Fire Marshal Division

**Re: Campbell University Tent
Barker Lane Stadium (180 Wade Stewart Circle)
Lillington, NC 27546**

Application Number FMFW1808-0007

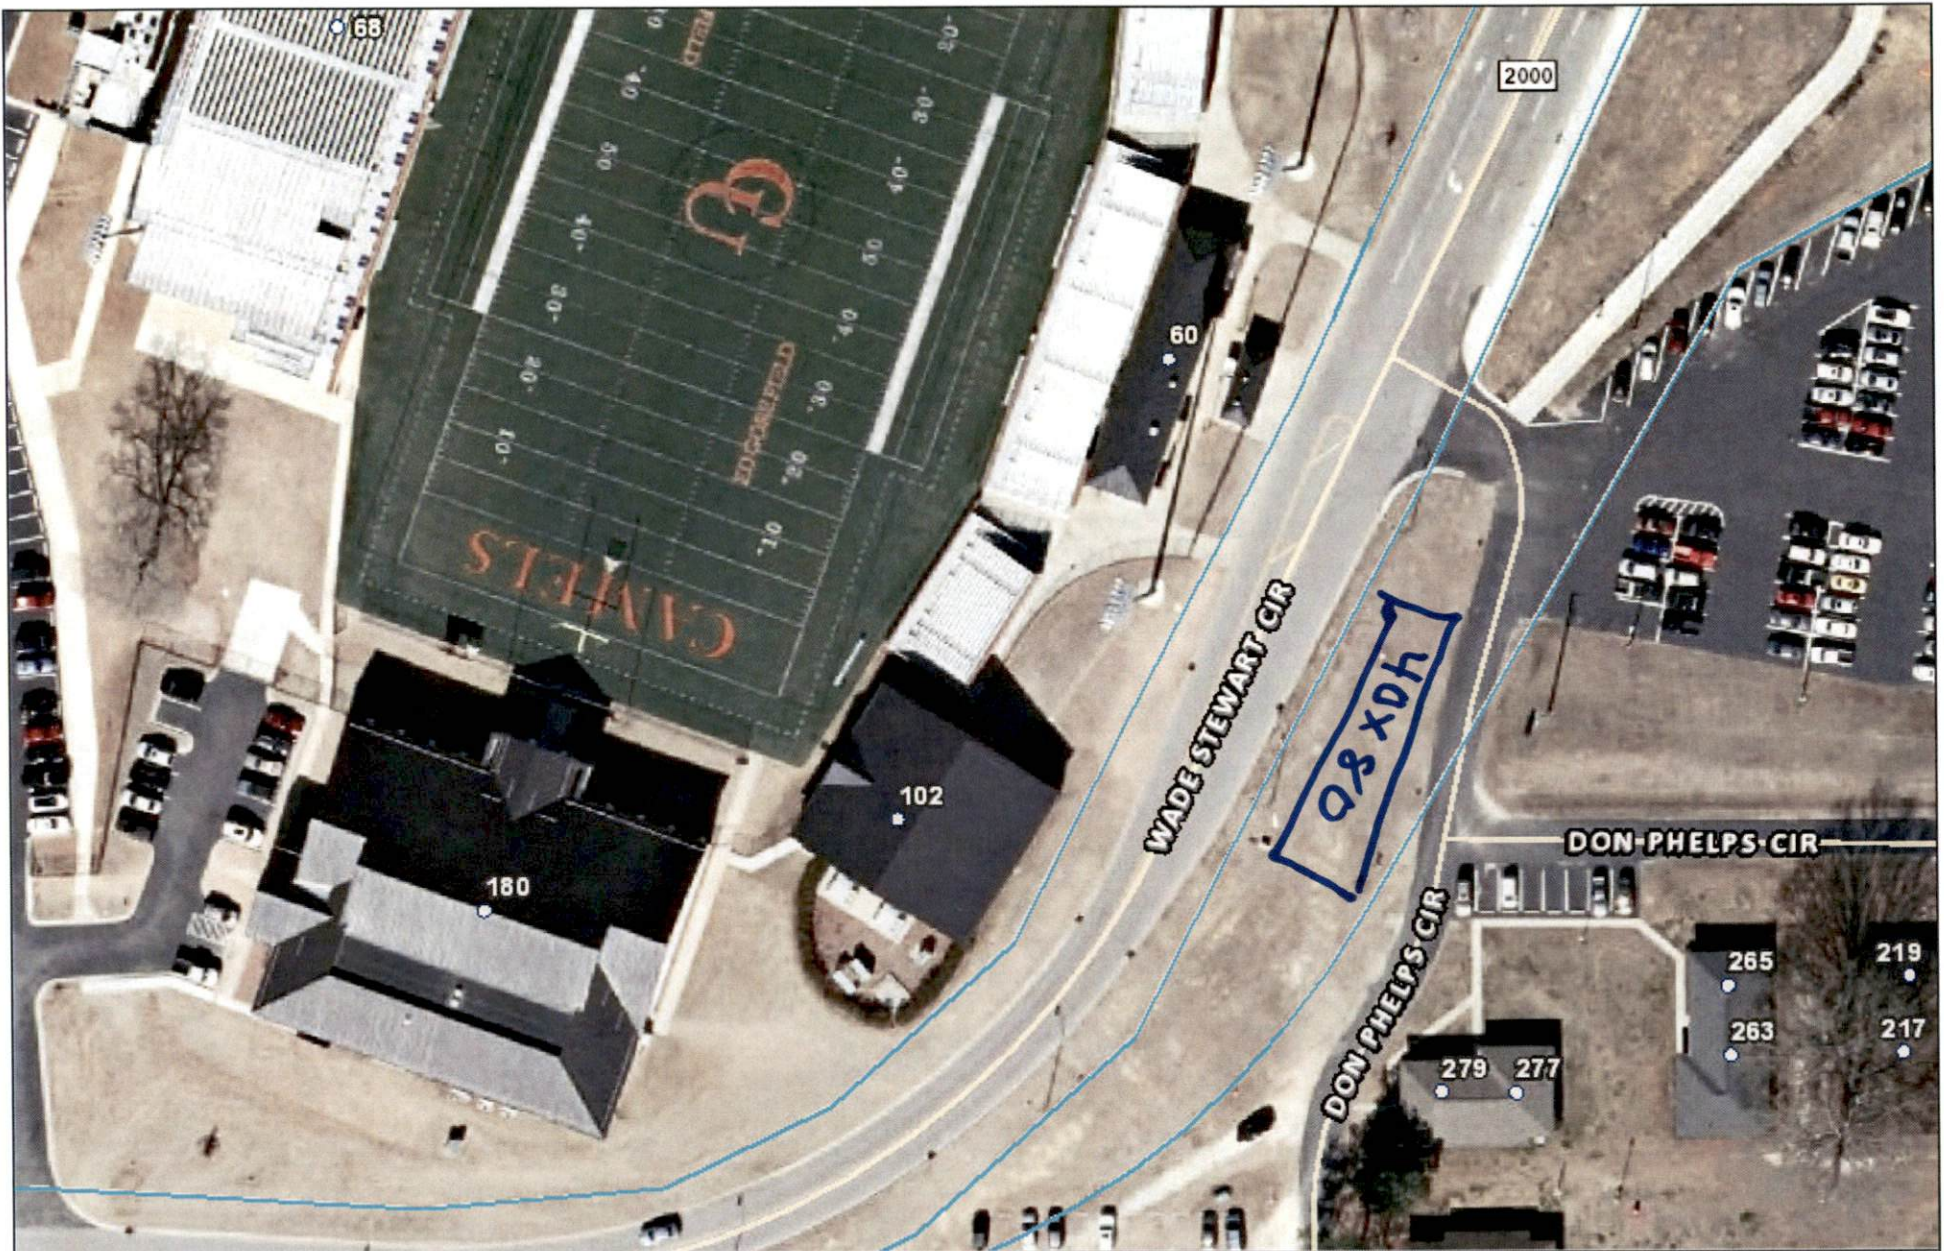
- **2404.12 Fire Extinguishers.**
 - 2A-10B: C fire extinguisher shall be placed at tents/canopies with a travel distance not to exceed 100' from any fire extinguisher.
- **2403.12.5.1 Arrangement of aisles.**
 - The arrangement of aisles shall be subject to the approval of the fire code official and shall be maintained clear at all times during occupancy.
- **2403.12.6 Exit Signs**
 - Exits shall be clearly marked. Exit signs shall be installed at required exit doorways and where otherwise necessary to indicate clearly the direction of egress when the exit serves an occupant load of 50 or more.

- Smoking shall not be allowed under tents/canopies. "NO SMOKING" signs shall be conspicuously posted under the tent.
